**REQUEST**

Current Zoning: R-20MF (multi-family)  
Proposed Zoning: MUDD-O (mixed-use development district, optional) with 5-year vested rights.

Approximately 8.55 acres located on the east side of Old Providence Road and west side of Providence Road, north of River Oaks Lane.

**SUMMARY OF PETITION**

SHEET NUMBER: RZ2-00

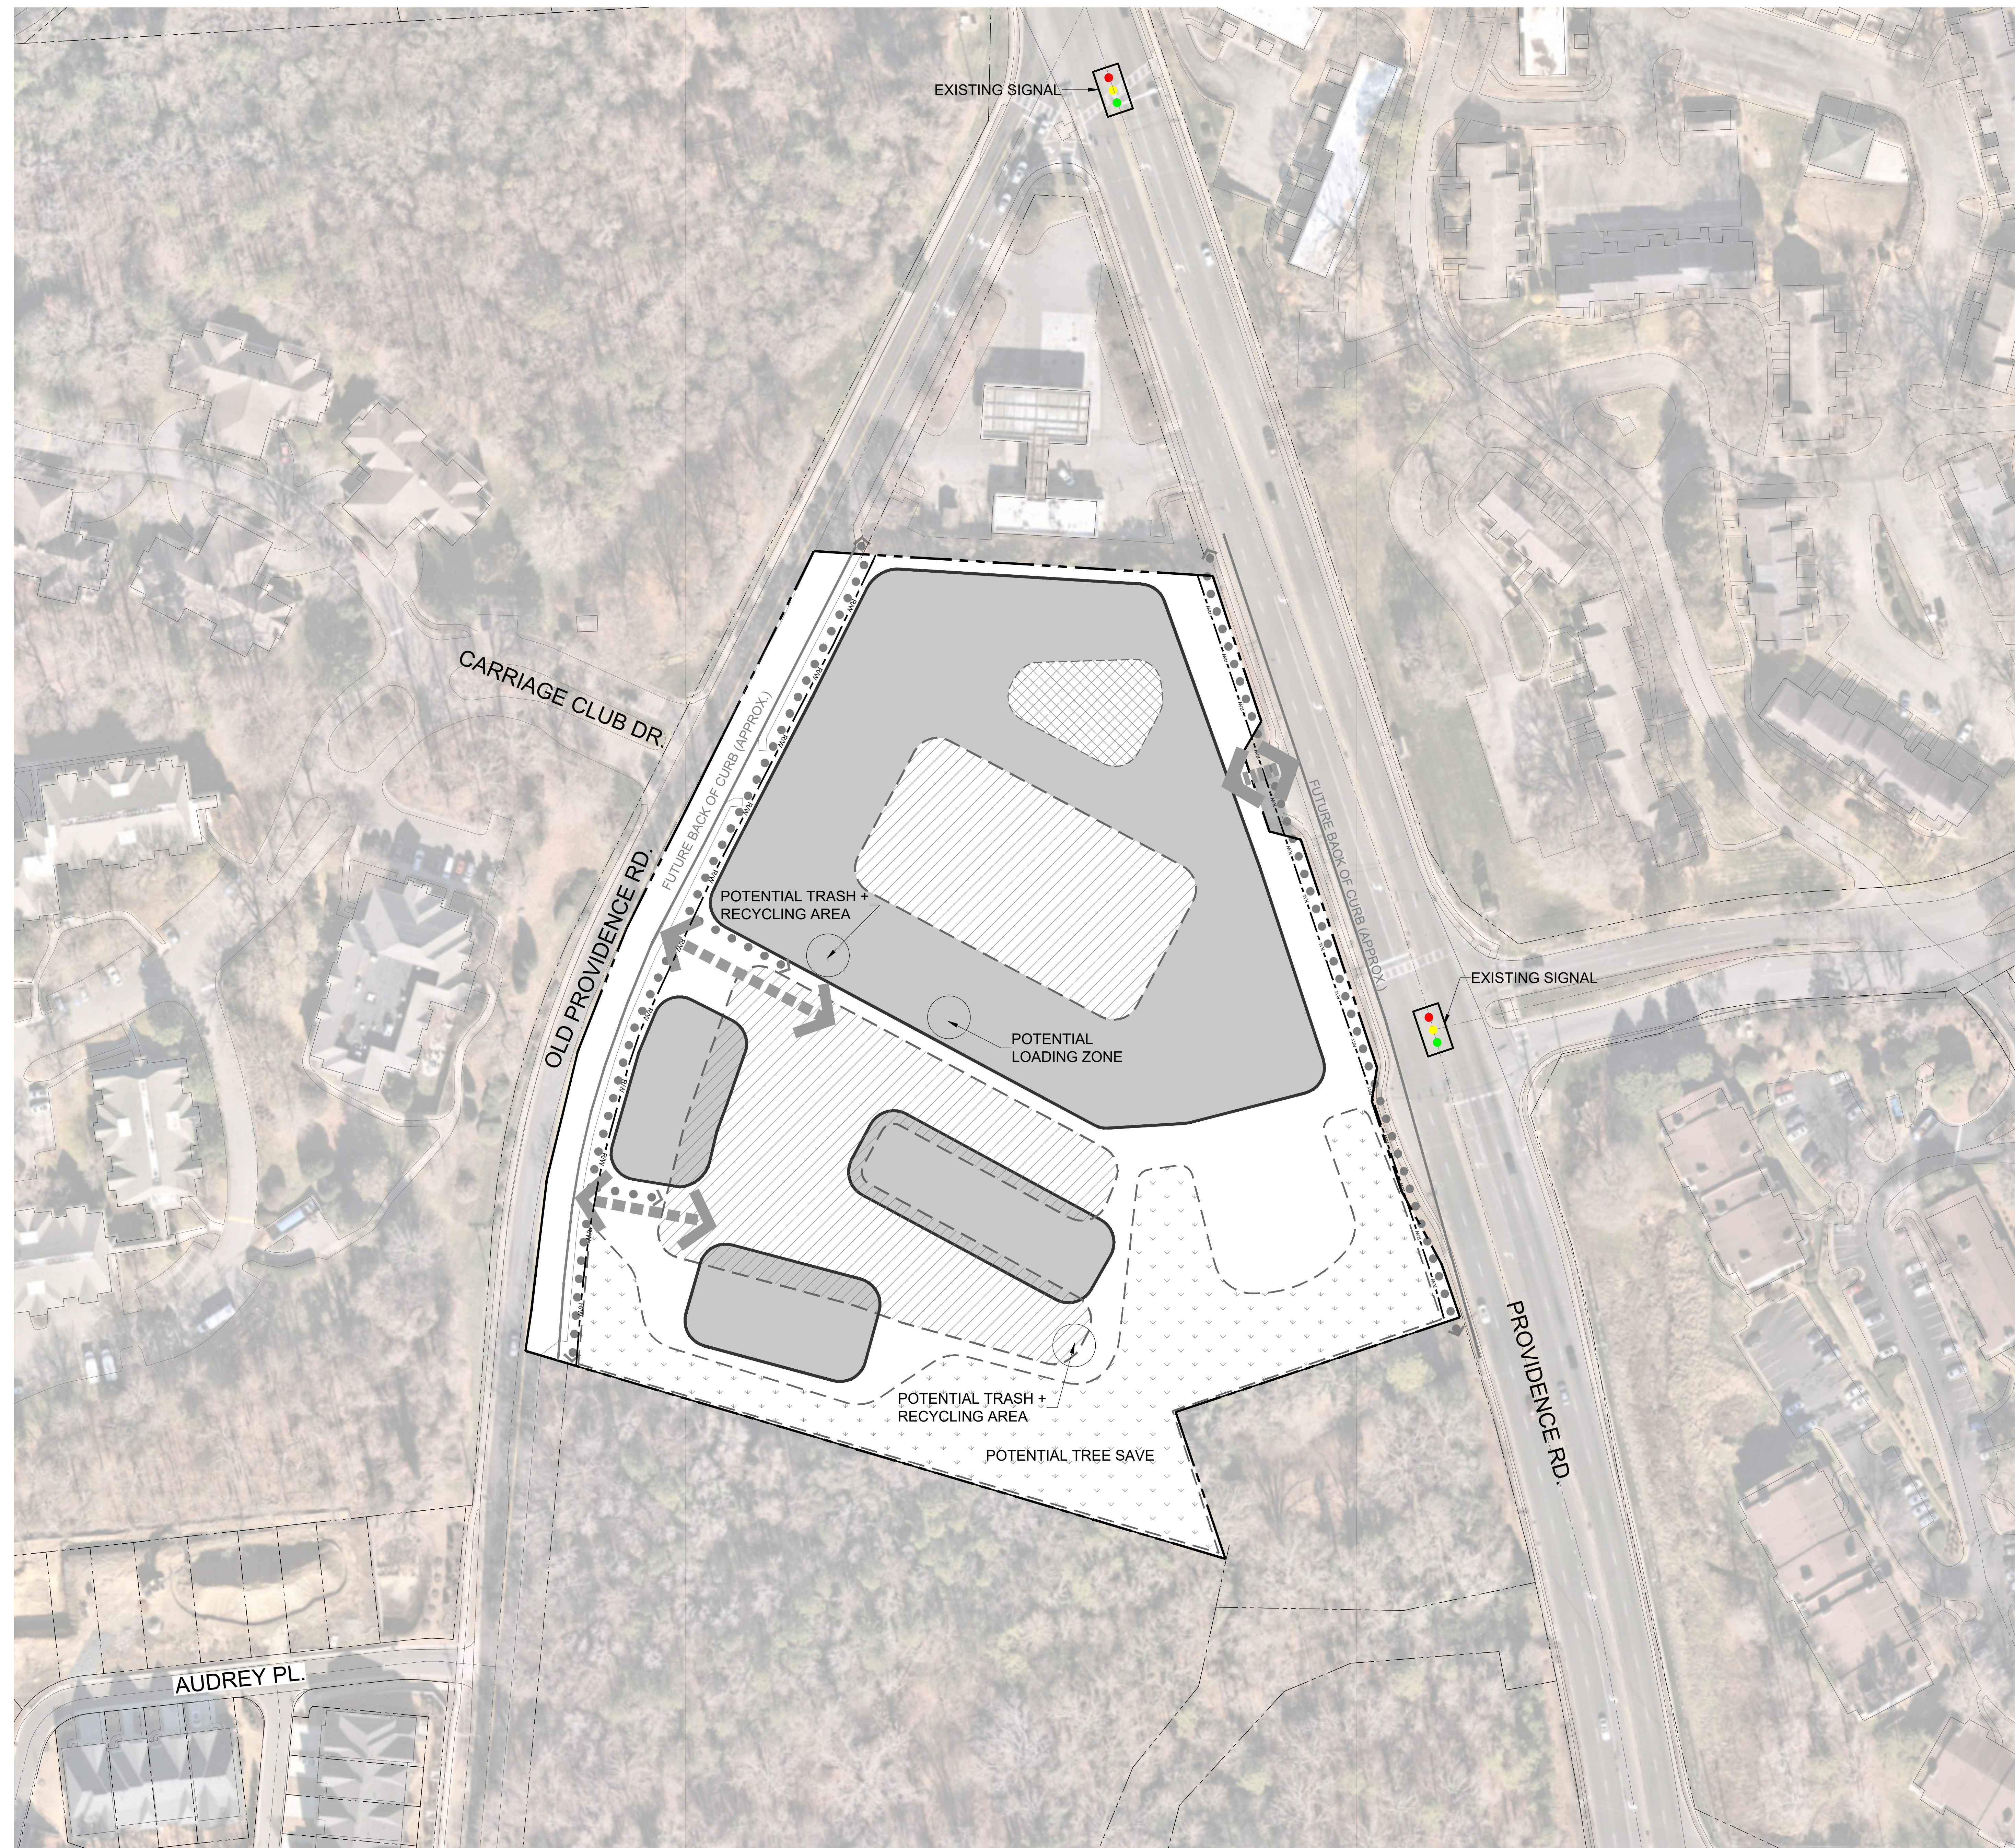
10. ~~CDOT: Ensure transportation improvements reflect what was in the TIS addendum. Only improvements for the Horizon piece were related to Access K and Old Providence Road.~~ **Addressed**
- #### Site and Building Design
11. ~~Entitlement Services: Show an approximate location of the pedestrian connection on the site plan. Coordinate this location with petition 2023-039.~~ **Addressed**
